April 17, 2018

RE: 415 Cumberland Avenue, 415 CA, LLC

Below are the responses to the Staff comments of April 3rd.

**A2.01**

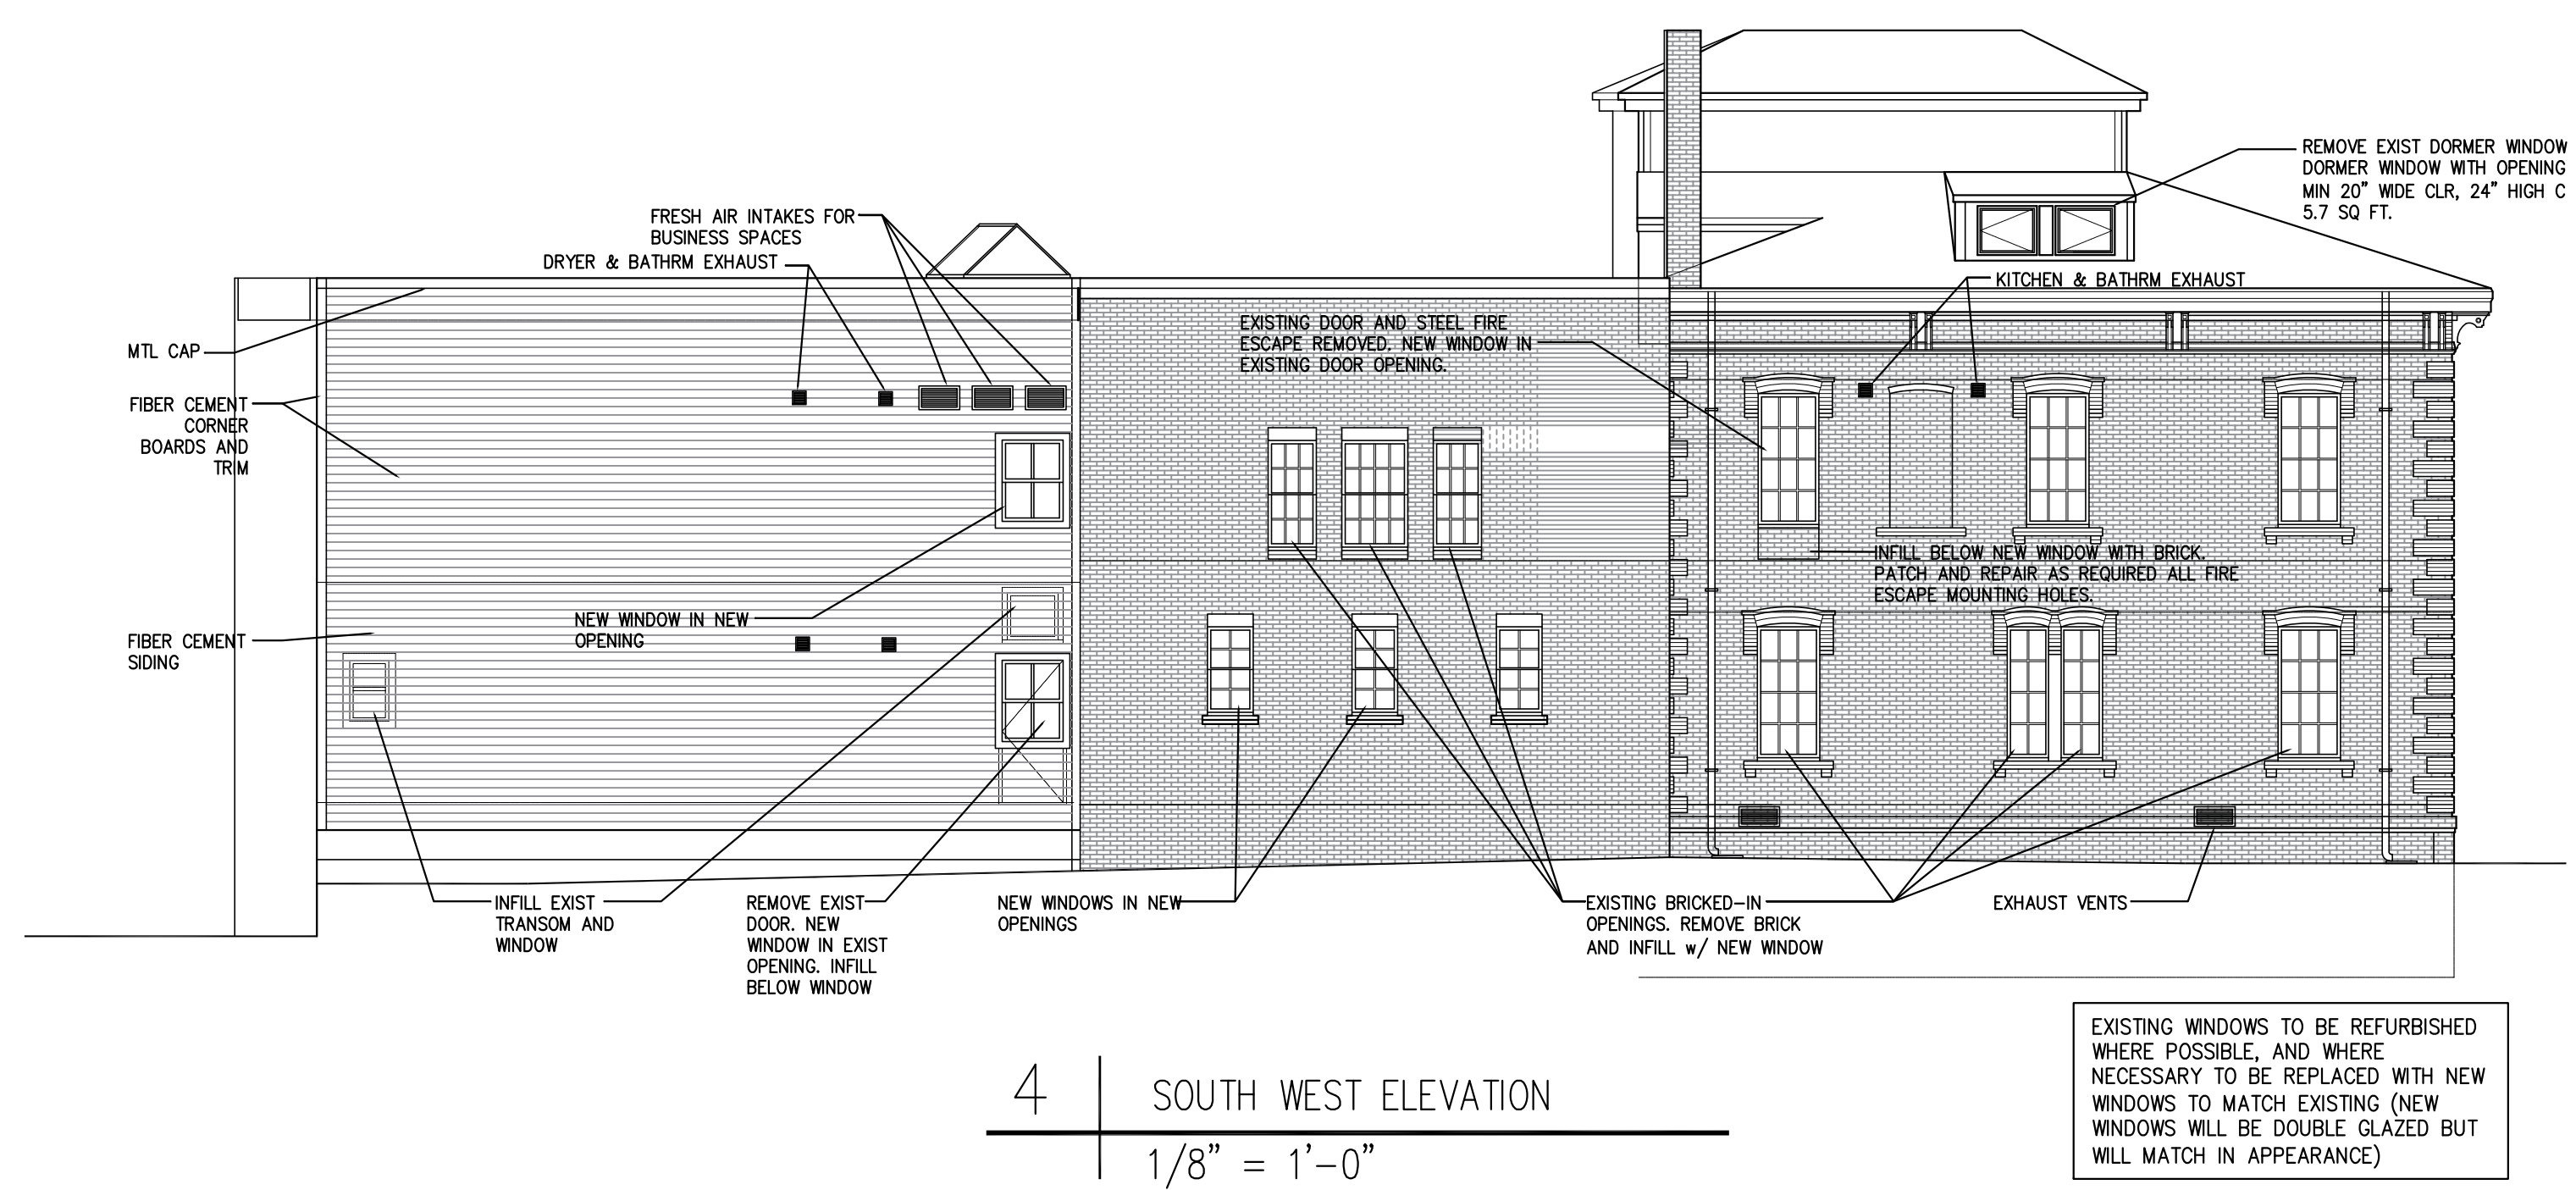
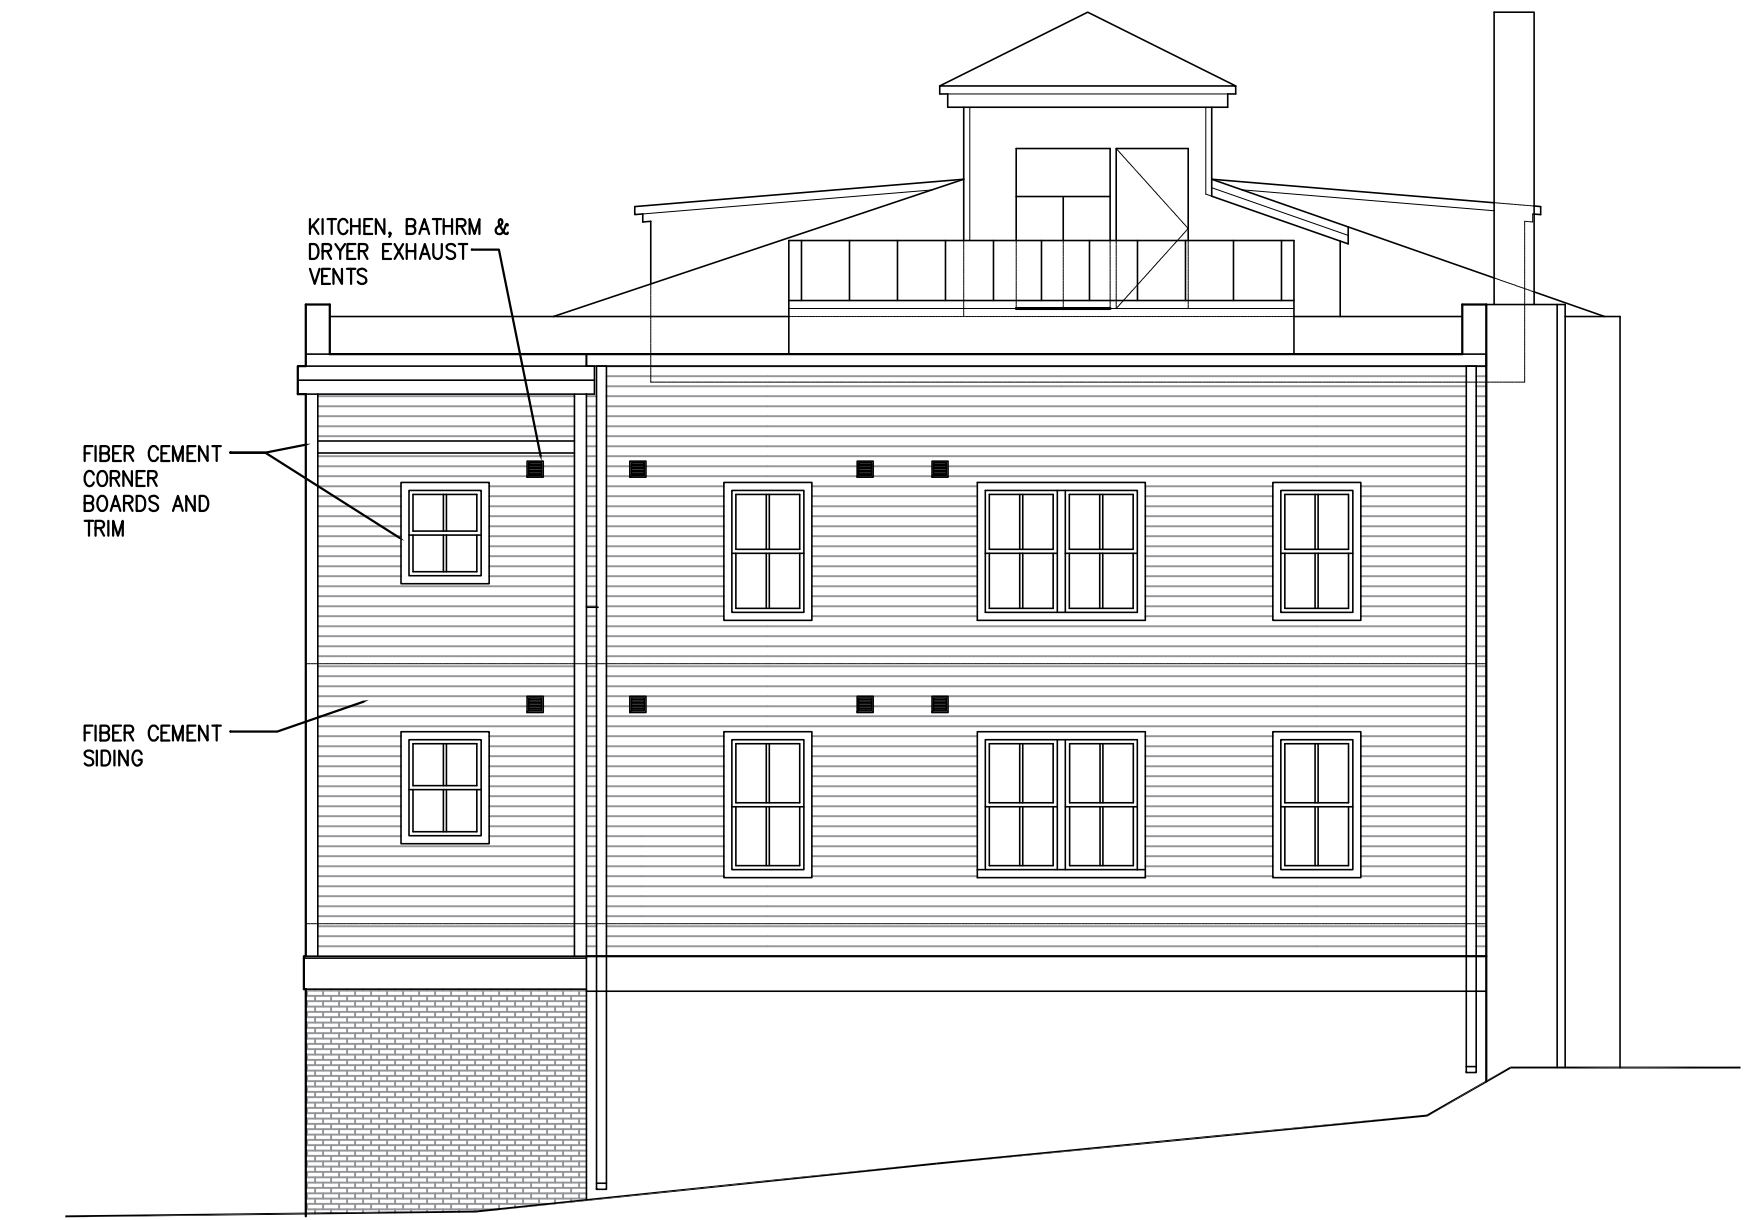
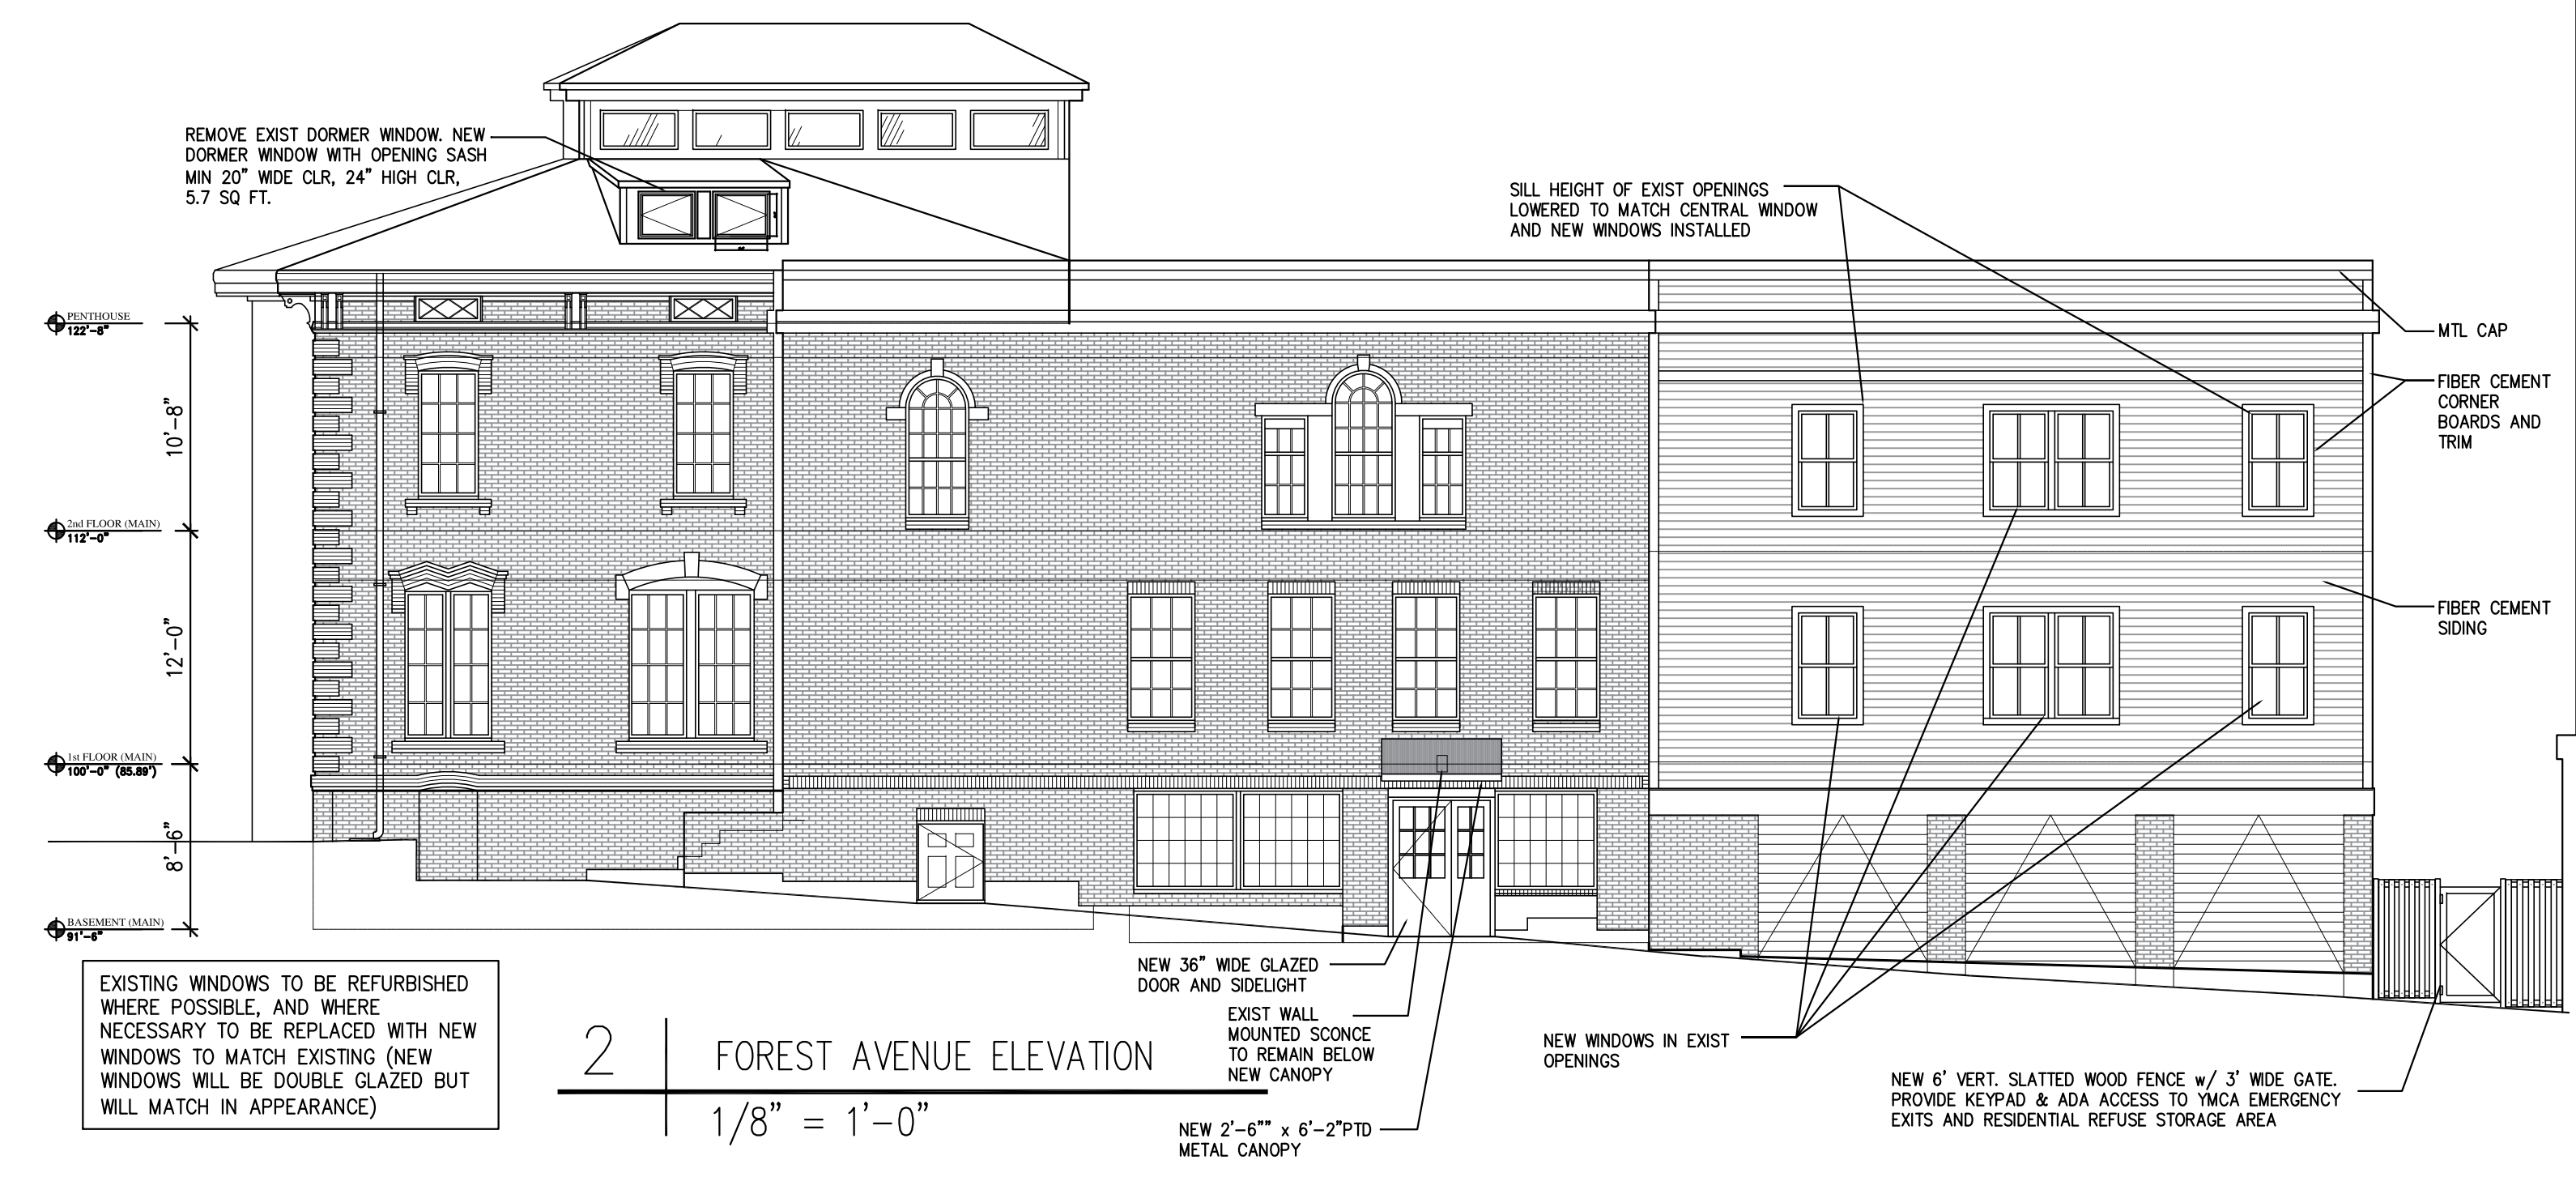
11. *Please provide details on new windows. What are the materials? Windows should feature simulated divided lites with applied exterior muntins, at a minimum. Also, please identify which windows will be repaired and which will be replaced.*

13. *Why are two windows on the northwest elevation a different height than all other windows on that elevation and the Forest Avenue elevation? Ideally these will all match.*

19. *Hardie plank at the top of the building parapets on the Forest Avenue and southwest elevations seems strange – the treatments / bands along the top of the building's middle section should be continued.*

The intent is to replace the 2nd floor windows in the brick building (residential units) and refurbish the 1st floor windows in the brick building (commercial spaces). All proposed windows in the clapboard building will be new. The revised elevations indicate which

existing windows will be refurbished and which will be replaced. The replaced windows will be aluminum clad windows with simulated divided lights. We have received quotes for replacement windows from Pella, Sierra Pacific, and Weathershield, and the replacement windows will be supplied by one of these manufacturers.

These two windows are located in kitchens and the sills are higher to allow for the kitchen counters. Currently the section of the elevation with these two windows is treated differently from the remainder of the elevation. The lower level is brick and not concrete, the gutters and rooflines are different, and there is a vertical trim board separating the two areas. We intend to maintain a trim board separating the two areas and this will mitigate the difference in sill heights.

This has been revised on the drawings to show hardie plank lap siding below the trim

and hardie panel above the trim.
